**Subject:** FG/19/21/PL

Proposal: **Change of use of flat above restaurant to a bar. This site is in CIL Zone 4 (Zero Rated) as other development.**

Address: **First Floor Flat 60 Ferring Street Ferring BN12 5JP**

TITLE	PROPOSED FIRST FLOOR PLAN & PARTY WALL TREATMENT DETAIL
-------	--

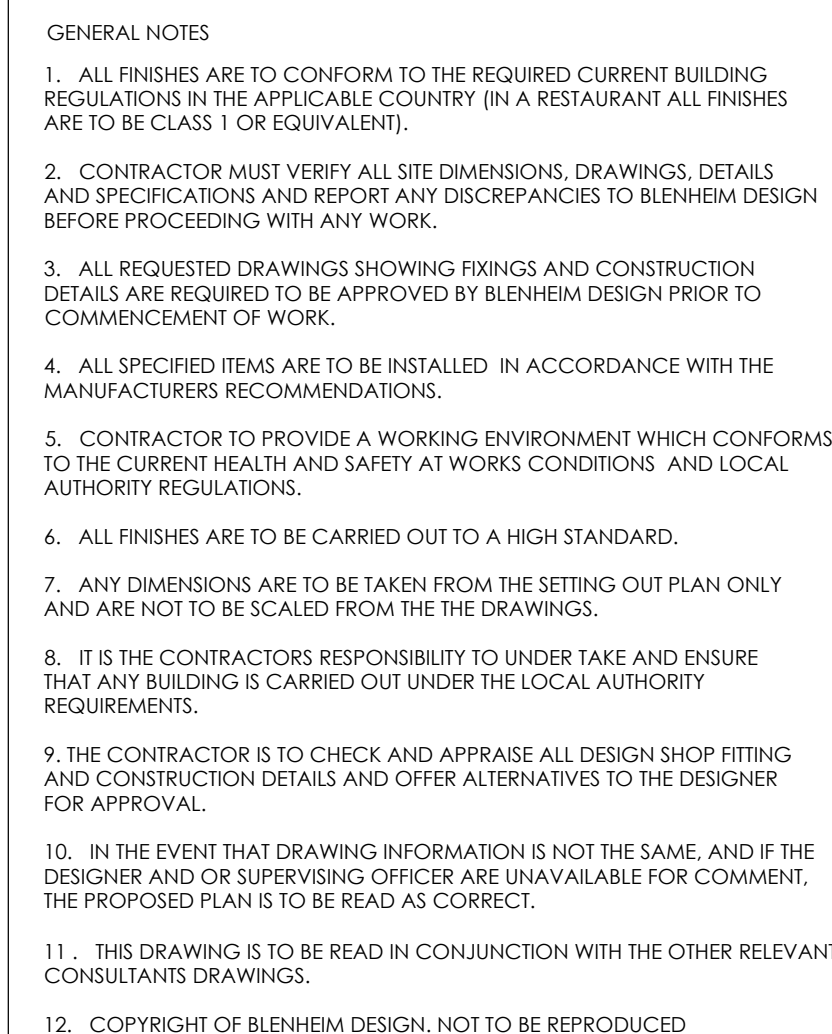
I have considered the proposed application and Environmental Health have considered the drawings in relation to the proposed sound insulation.

Prior to the first use of the premises, details of any plant (including ventilation, refrigeration and air conditioning) and / or ducting system to be used and the method of control of noise and vibration of this plant shall be submitted to and approved in writing by the Local Planning Authority. The development shall be carried out in accordance with the approved details. The scheme shall ensure that the noise and vibration generated at the boundary of any noise sensitive property shall not exceed Noise Rating Curve: NR35 as defined within Table B.1: Noise Rating Values of BS 8233:2014.
